Application No: Y/31/21/PL
Site Address: Land East of Drove Lane Yapton BN18 0EB
Description of works: Temporary sales cabin & associated landscaping. This application may affect the setting of listed buildings, may affect the character & appearance of the Main Road/Church Road Conservation Area & is in CIL Zone 3 (Zero Rated) as other development.

Thank you for your internet representation made on 26th April 2021 which has been recorded as an objection with the comments as follows:

Barratt Static Banner
Barratt Logo
Flags - 600mm x 2200mm

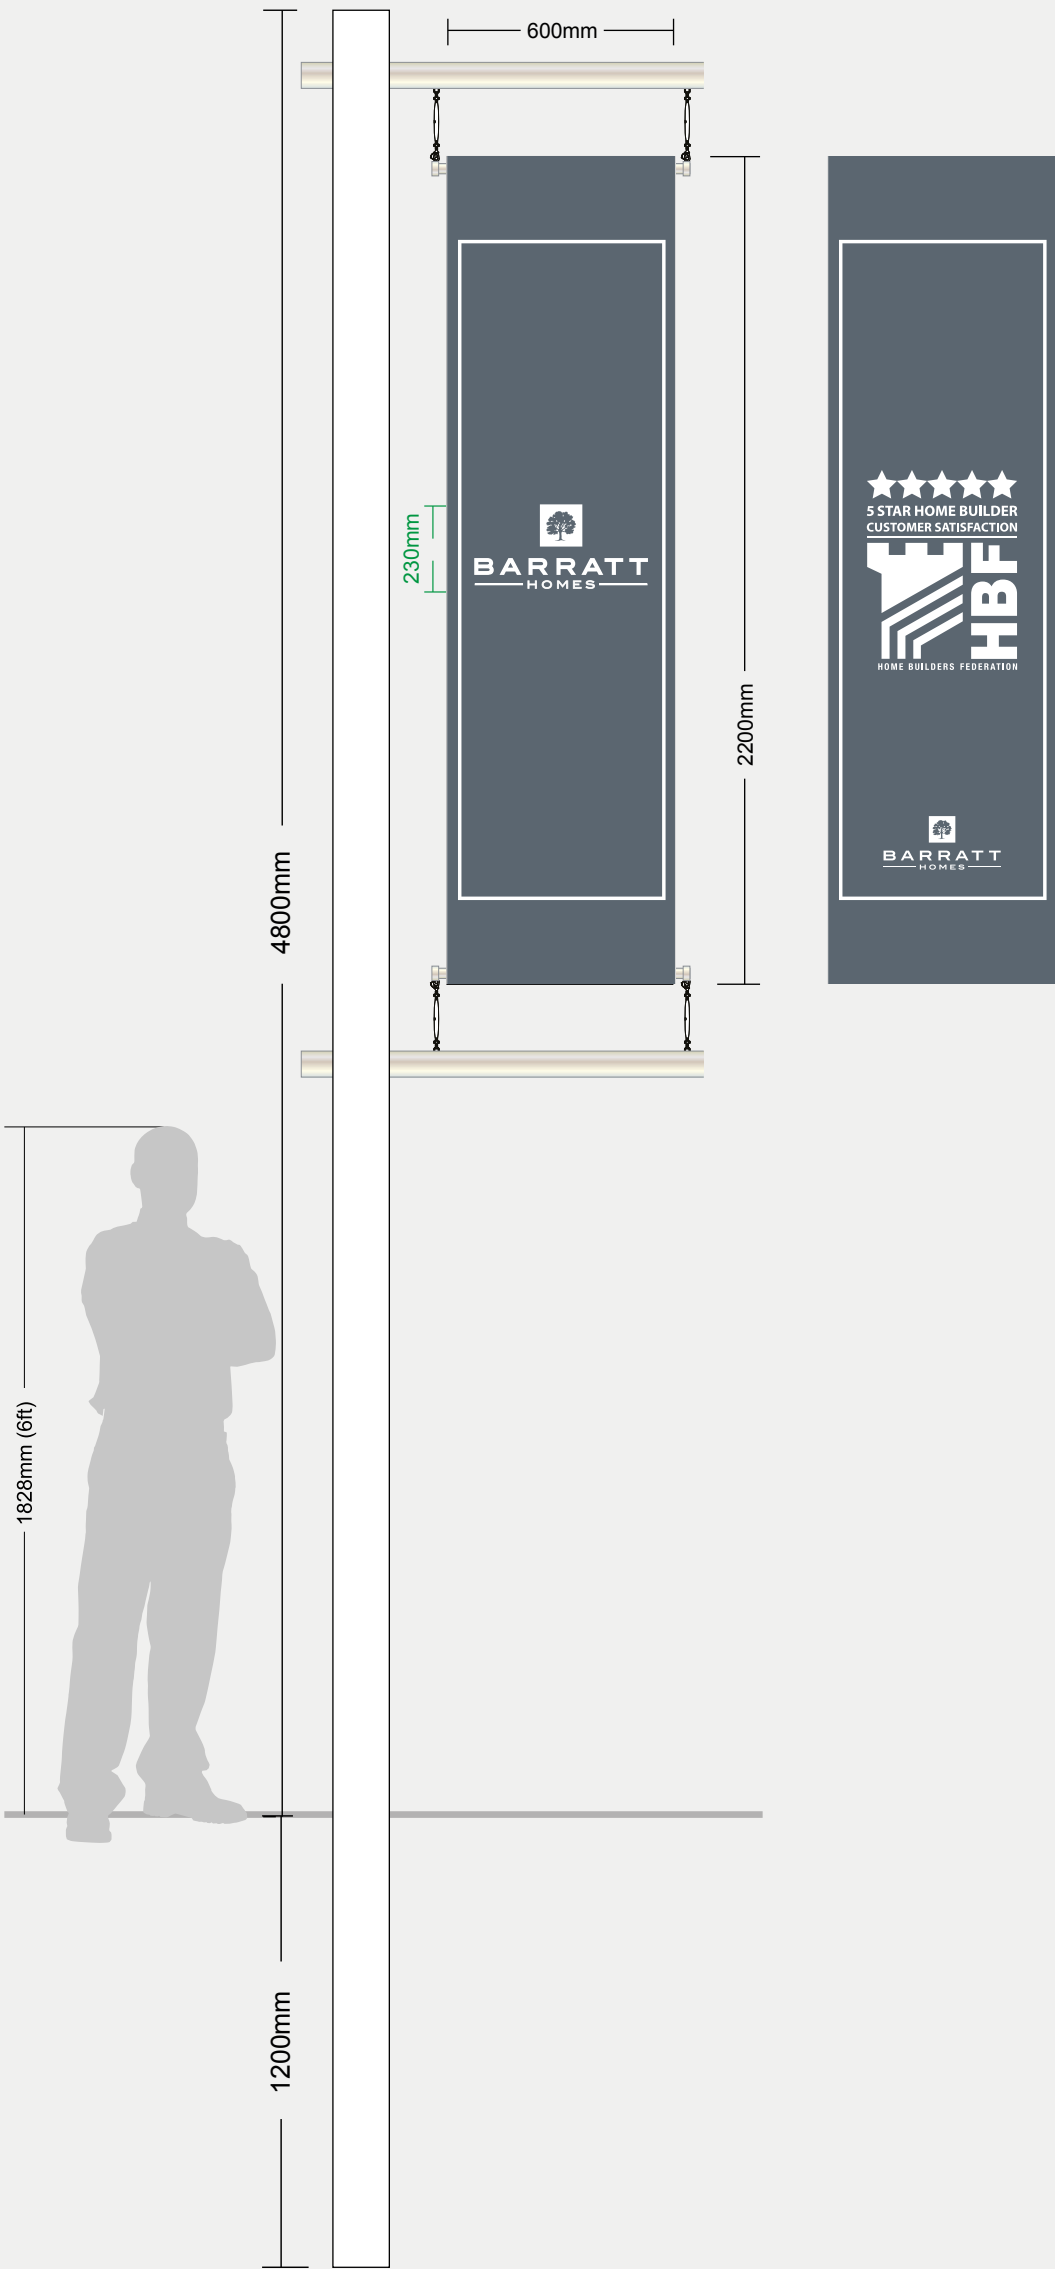
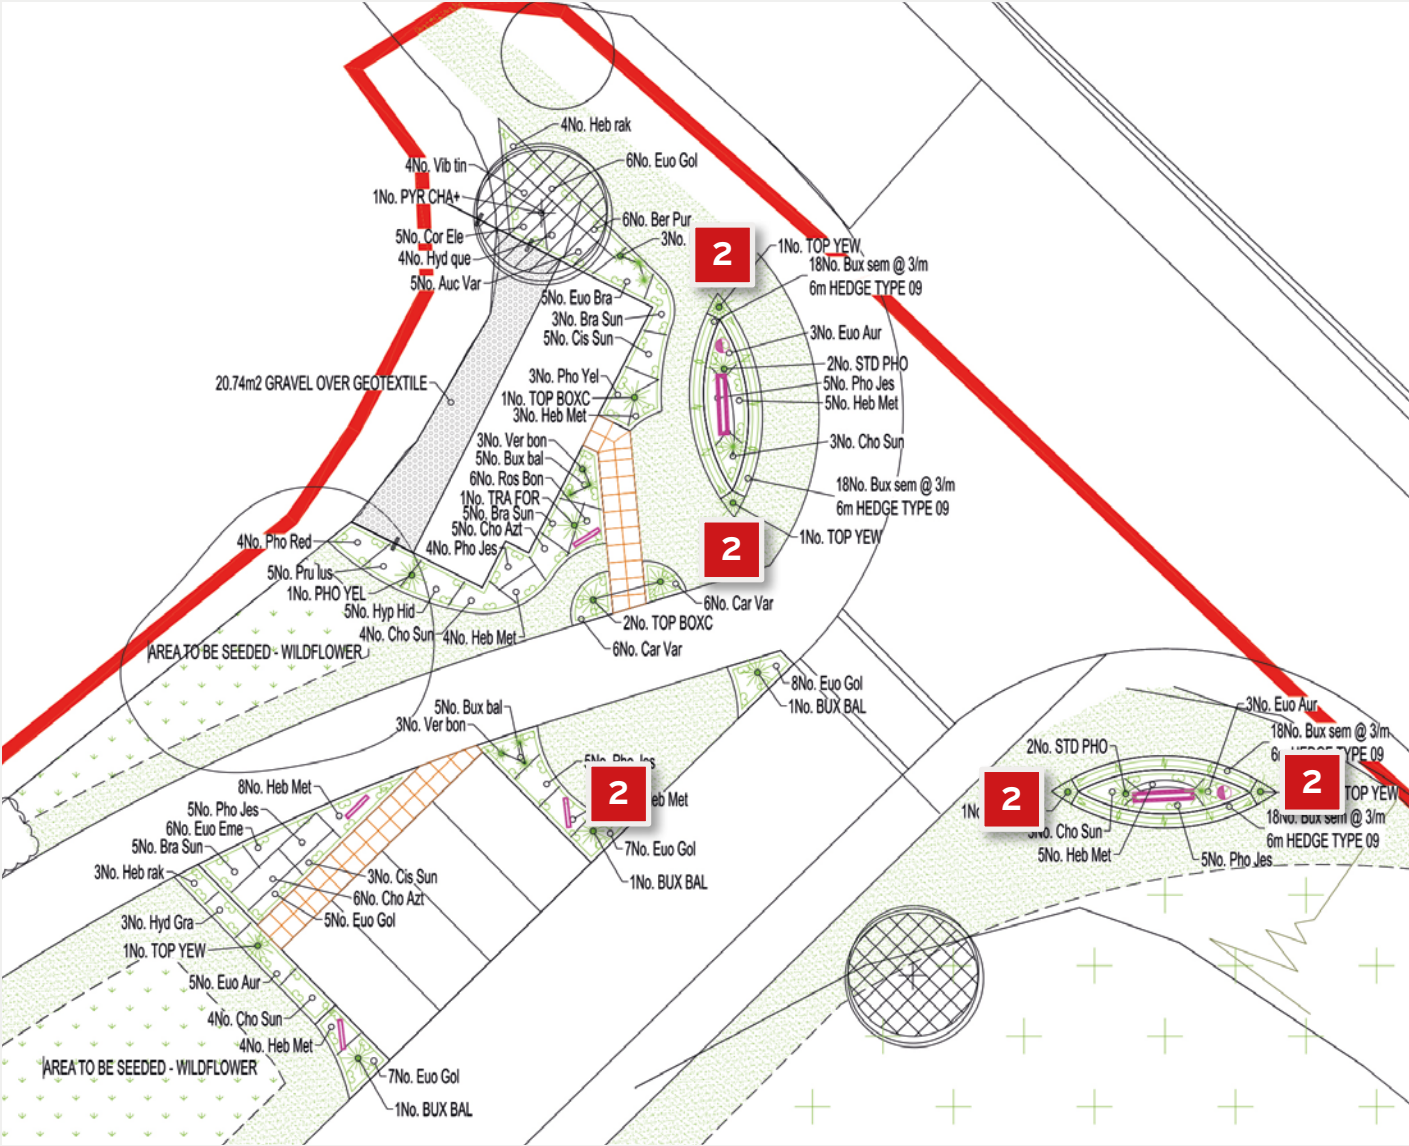
Sales office / flags / banners etc should be built and retained within the site so as not to distract drivers / cyclists along the main road. There will be a further entrance onto the main road at this point from Bonhams field opposite and along with the blind bend this would create a hazard.

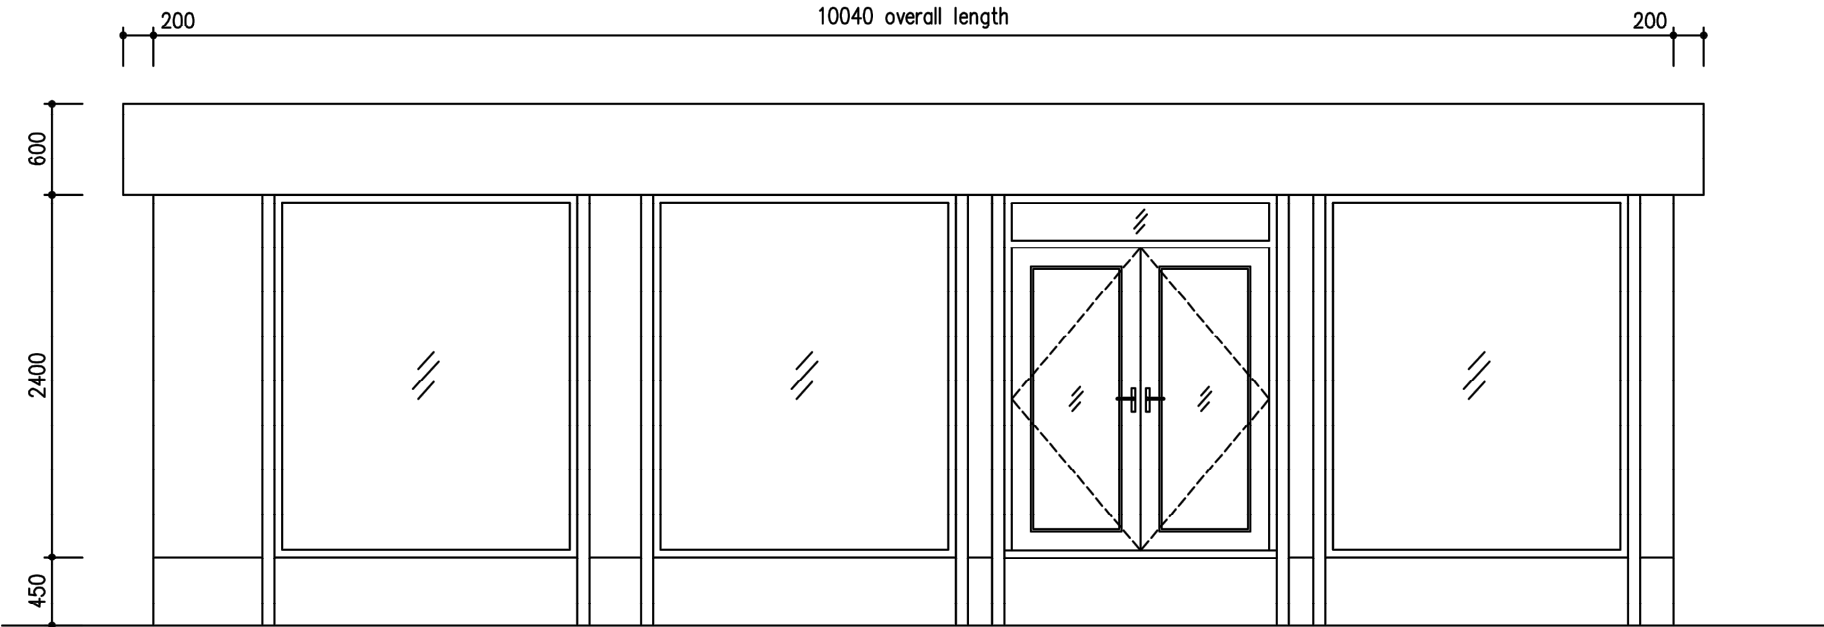
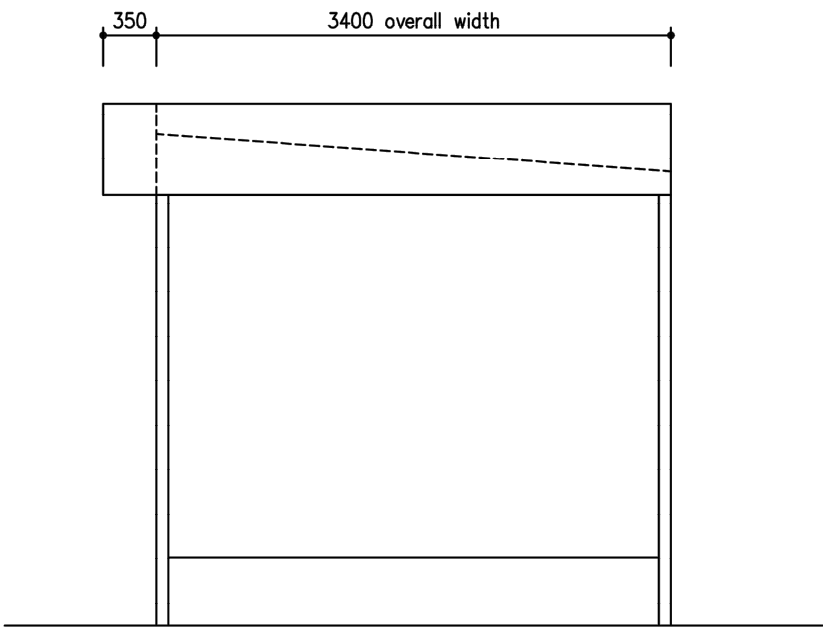
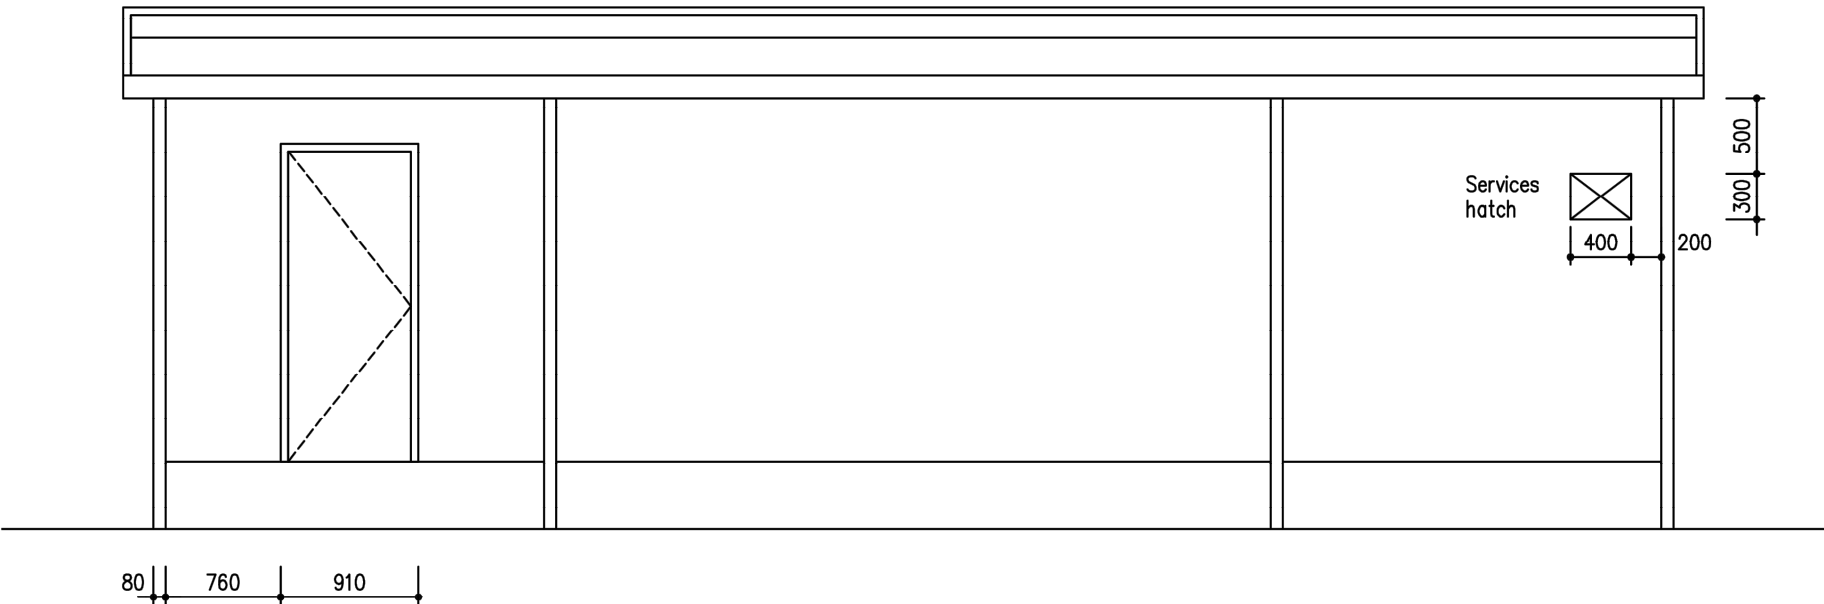
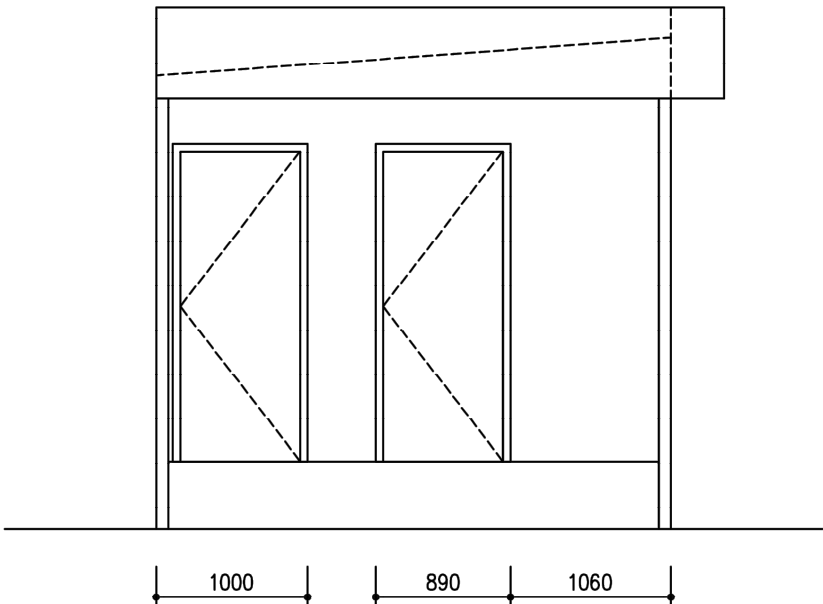
Of course this is a rural setting with views over the South Downs and the structure would not be in keeping with village and may deter buyers
